April 22, 1986

RE: DRAINAGE PLAN SUBMITTAL OF RETAIL DEVELOPMENT FOR HAROLD  
TIDENBERG, RECEIVED APRIL 10, 1986 FOR BUILDING PERMIT  
APPROVAL (H-17/D42)

RE: DRAINAGE AND GRADING PLAN FOR RETAIL DEVELOPMENT FOR HAROLD  
TIDENBERG (H-17/D-42)

DESIGNED BY: S.D.	<b>DRAINAGE &amp; GRADING PLAN</b> <b>RETAIL BUILDING</b> <b>ON</b> <b>SAN MATEO N.E.</b>
DRAWN BY: C.M.	
CHECKED BY: E.D.	
PREPARED BY: FEB 1986	<b>RESOURCE TECHNOLOGY INC.</b>

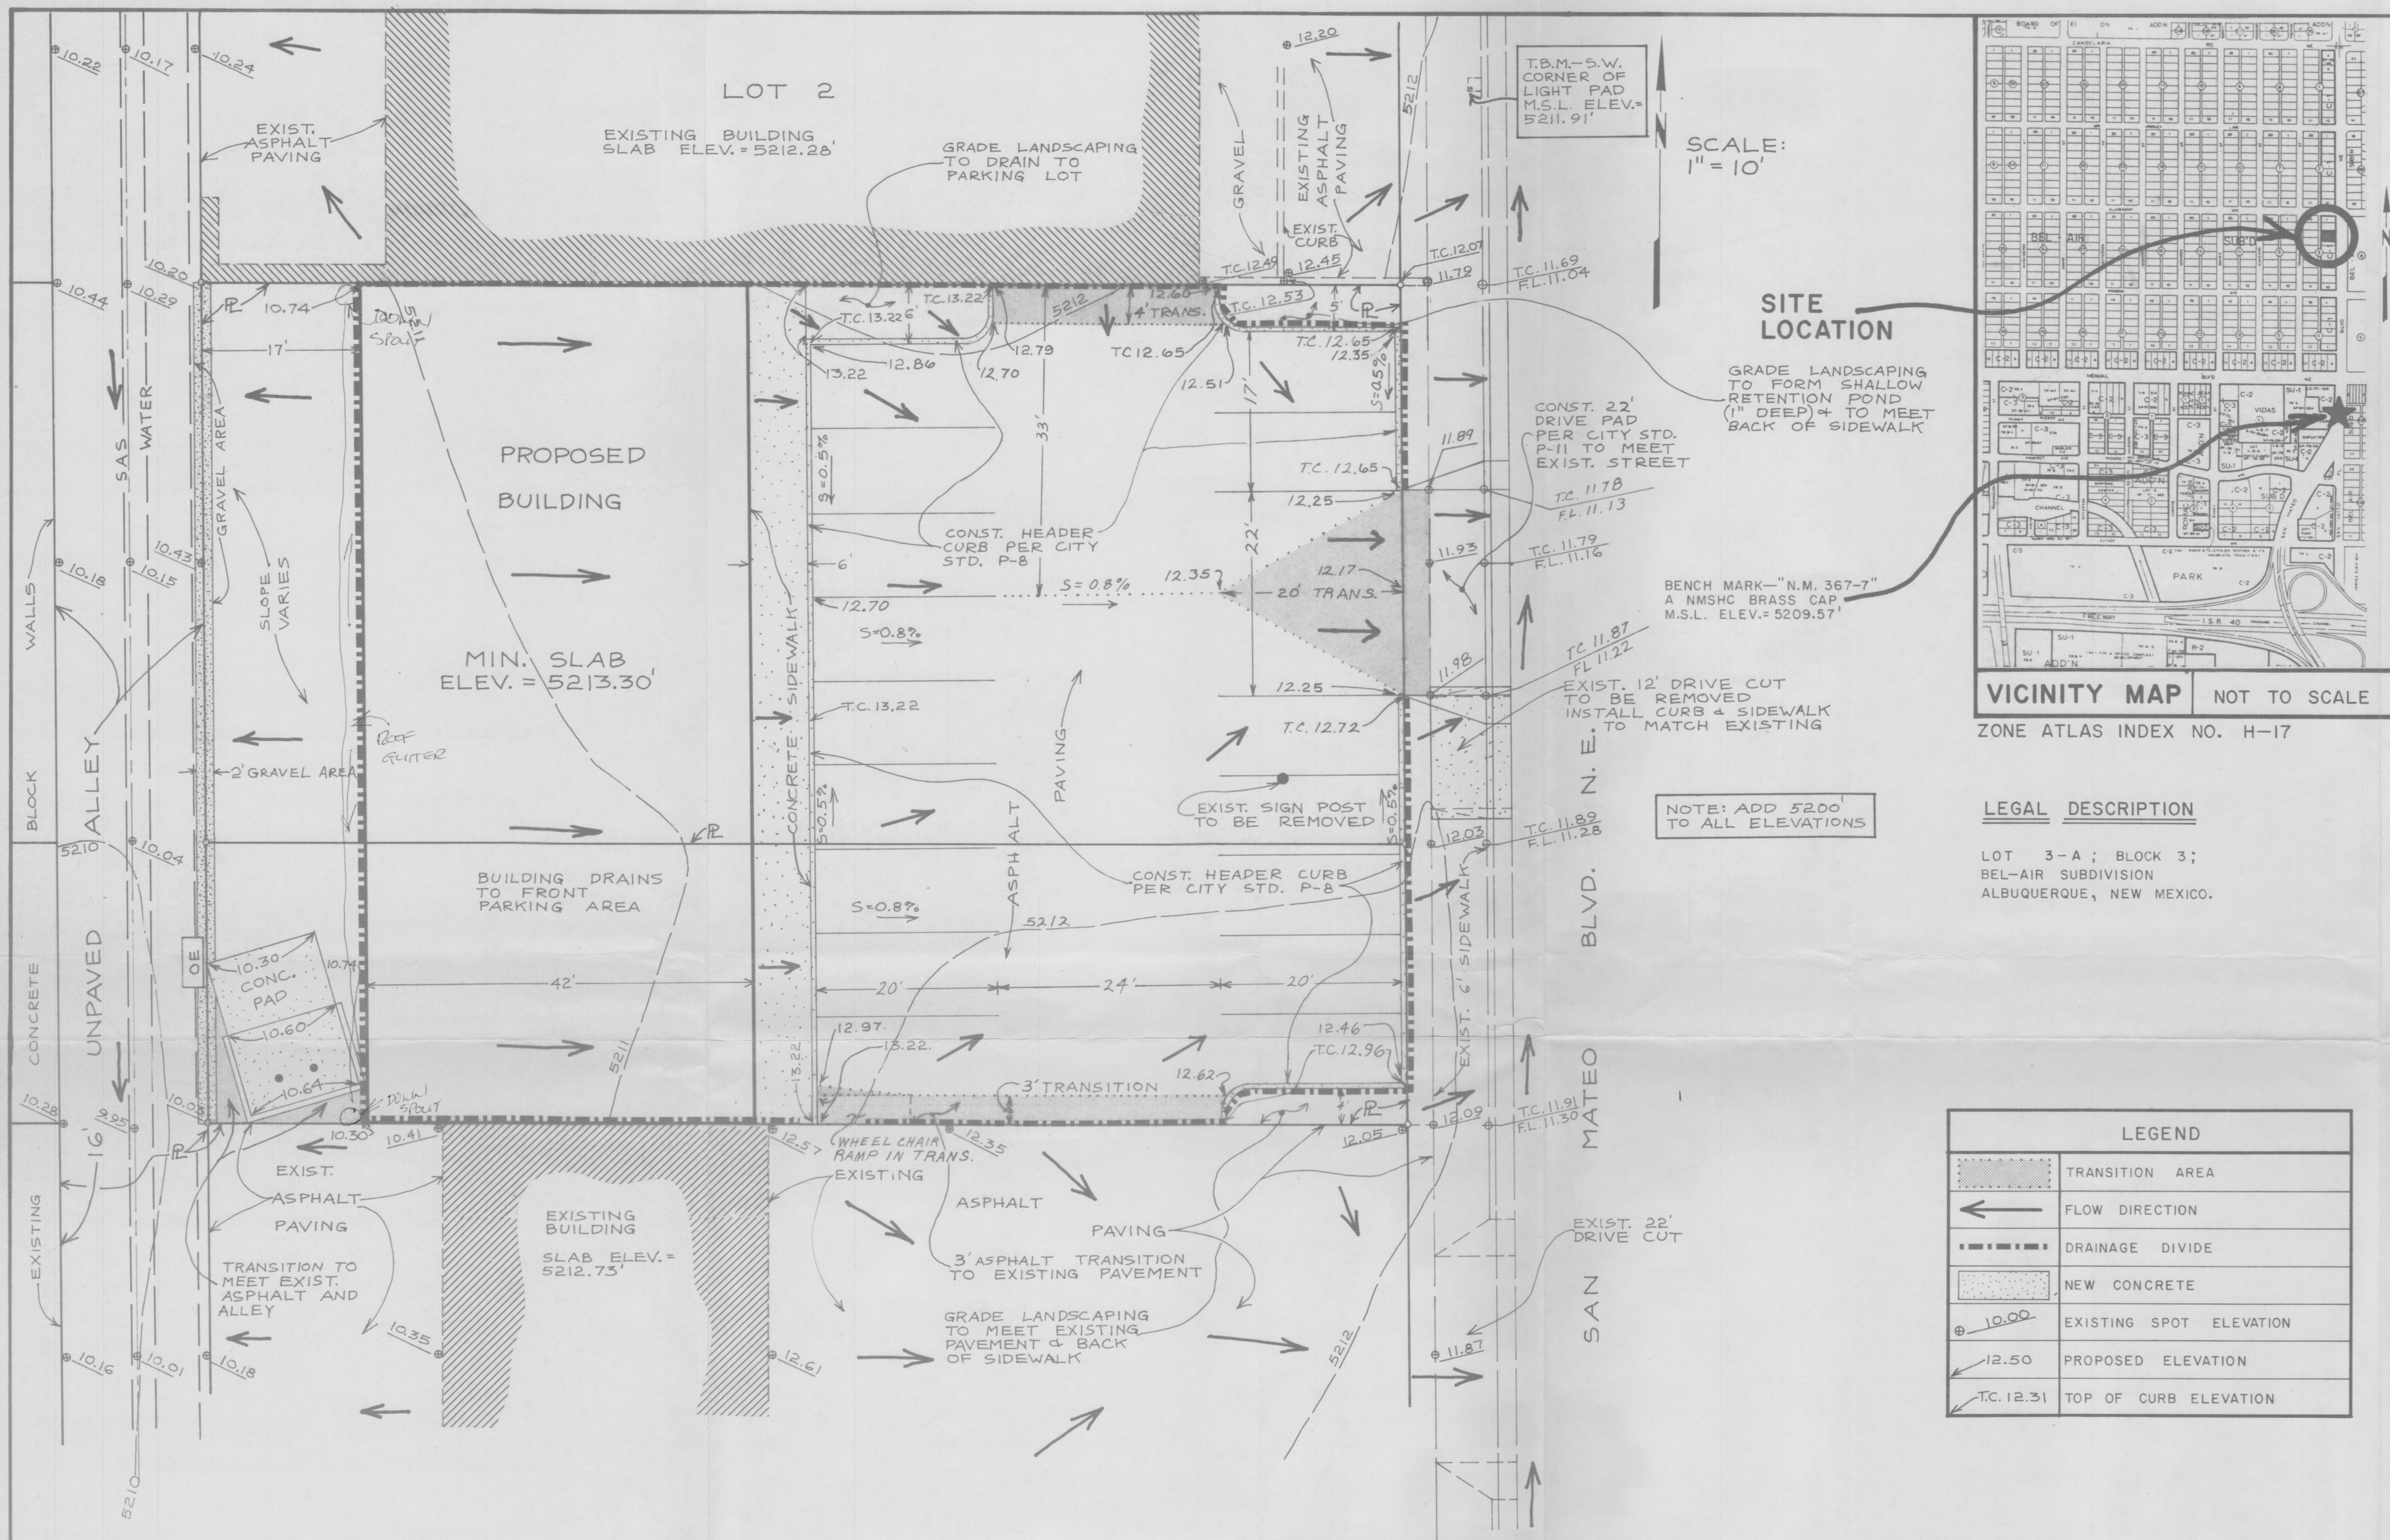
The above referenced submittal, revised April 9, 1986, is approved for Building Permit sign-off. Approved alley grades will not be a requirement for Certificate of Occupancy, as previously requested by our office, because of the reasons stated in your letter dated April 9, 1986. Certification of finish floor elevation will be required for Certificate of Occupancy.

This letter discusses the 16-foot wide unpaved alley directly west of the project referenced above.

2. The grades on the alley now are very shallow. To raise these grades to meet City Standards would require raising the alley 1-foot above flow line at the Right-Of-Way line and to comply with the minimum slope criterion of 0.5% it would raise one more foot at the center of the alley for a total of 2 feet above street flow line elevations. At present the maximum elevations of the alley are only 1.29 and 1.62 feet above the street flow line at Claremont and Phoenix Avenues respectively. If City Standards are complied with, existing paved strips along the back of the commercial tracts, which now grade to the alley, would no longer be able to drain to the alley because they would be lower. Also, the new alley would require a fill slope along the back of the residential lots where many residents use the alley for backyard access to vehicles.

Therefore, we strongly recommend that the alley grade be allowed to remain as-is. The present system works well and we see no real need to create a drainage problem when there isn't one at present. If you have any questions please call me.
